V3_Drainage Letter_COMMENTS.pdf Markup Summary

DRAINAGE LETTER REPORT

**FALCON BAPTIST CHURCH
11095 EGGAR DRIVE, PEYTON, CO 80831
LOT 1, HADDEN HEIGHTS**

**JPS Project No. 012502
PCD File No.: PPR2516**

FALCON BAPTIST CHURCH BUILDING ADDITION
LOT 1, HADDEN HEIGHTS

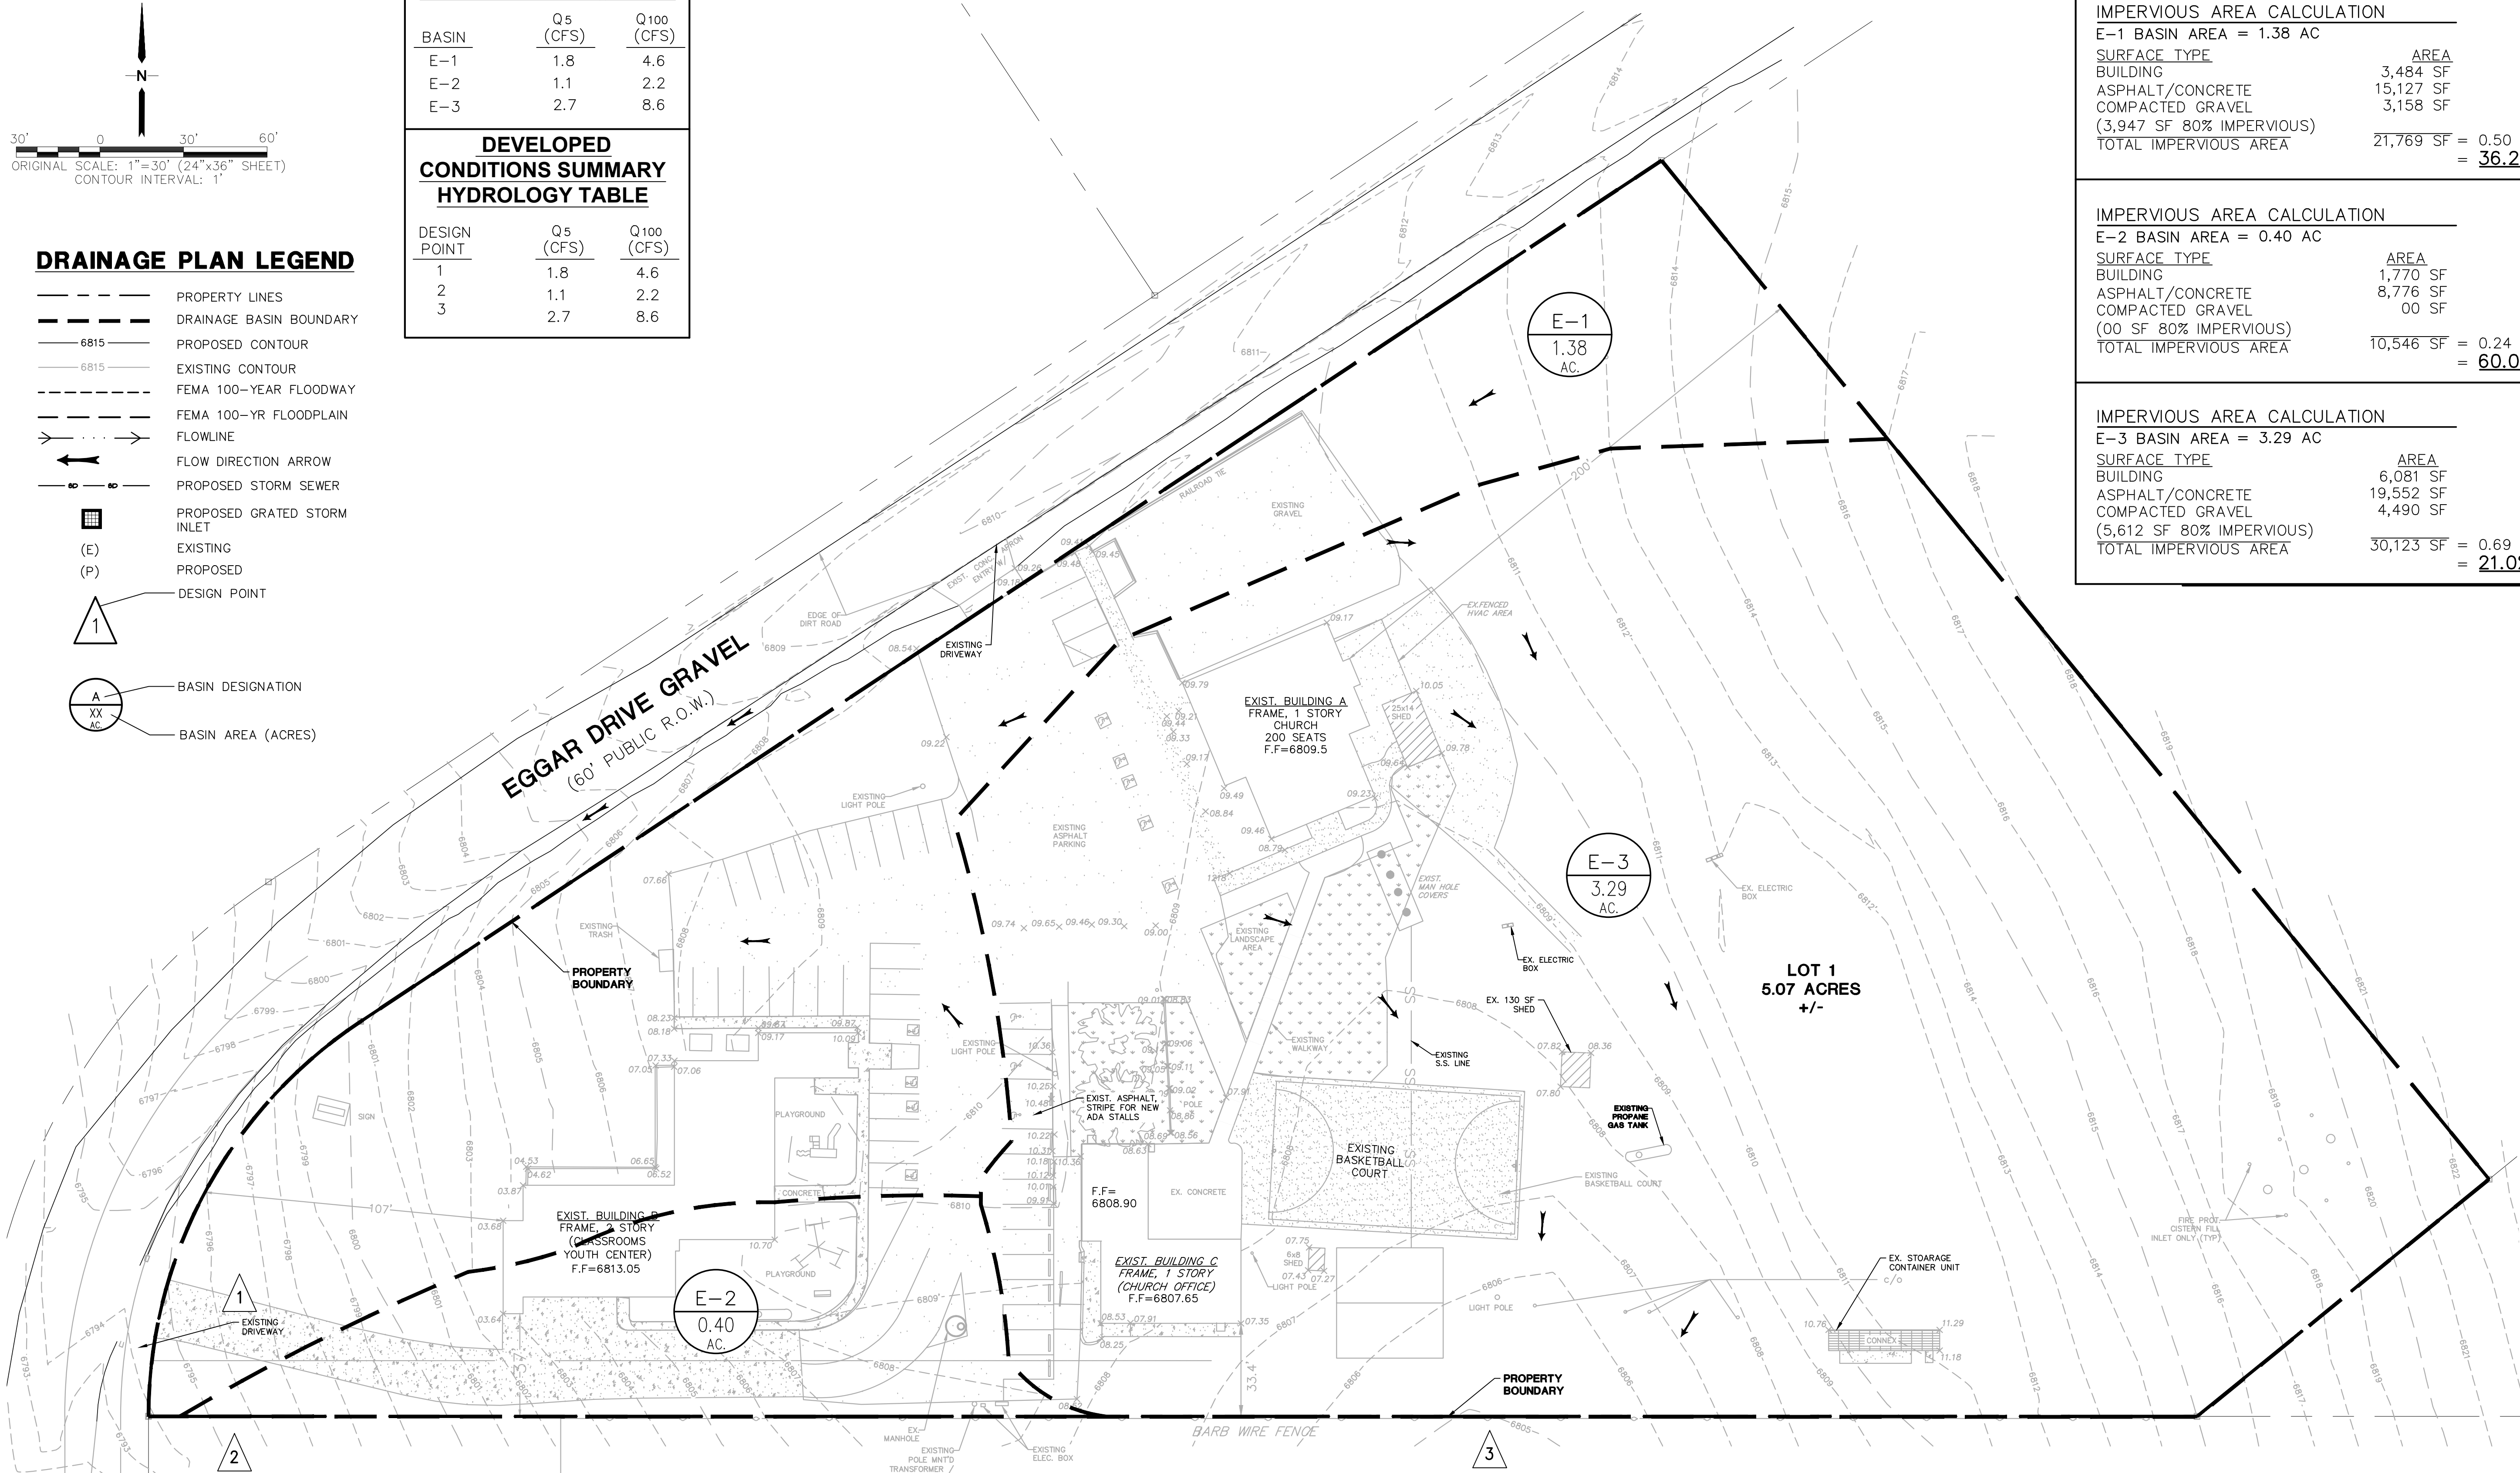
Previous unresolved comment:
We need to know how much of the proposed (and post-2008) area of disturbance (not just the impervious surfaces) is treated vs untreated and if there are any exclusions that apply to the untreated areas. So please create a basic overview map (or modify an existing drainage map) with color shading/hatching that shows areas tributary to each PCM (pond, runoff reduction, etc.) and those disturbed areas that are not treated by a PCM, with the applicable exclusion labeled (ex: 20% up to 1ac of development can be excluded per ECM App I.7.1.C.1 (only if using the WQCV Design Base Standard) and exclusions listed in ECM App I.7.1.B.#). An accompanying summary table on this map would also be very helpful. Example provided:

Previous unresolved comment:
Please quantify these post-2008 disturbances and categorize them as excluded or non-excluded and discuss the applicable exclusions. The PPR07014 plans were actually approved in 2009 and thus count towards the post-2008 (it's post March 10, 2008 to be specific) disturbances, even though the file number is from 2008.

Include detained release flow

Please add pond release rate
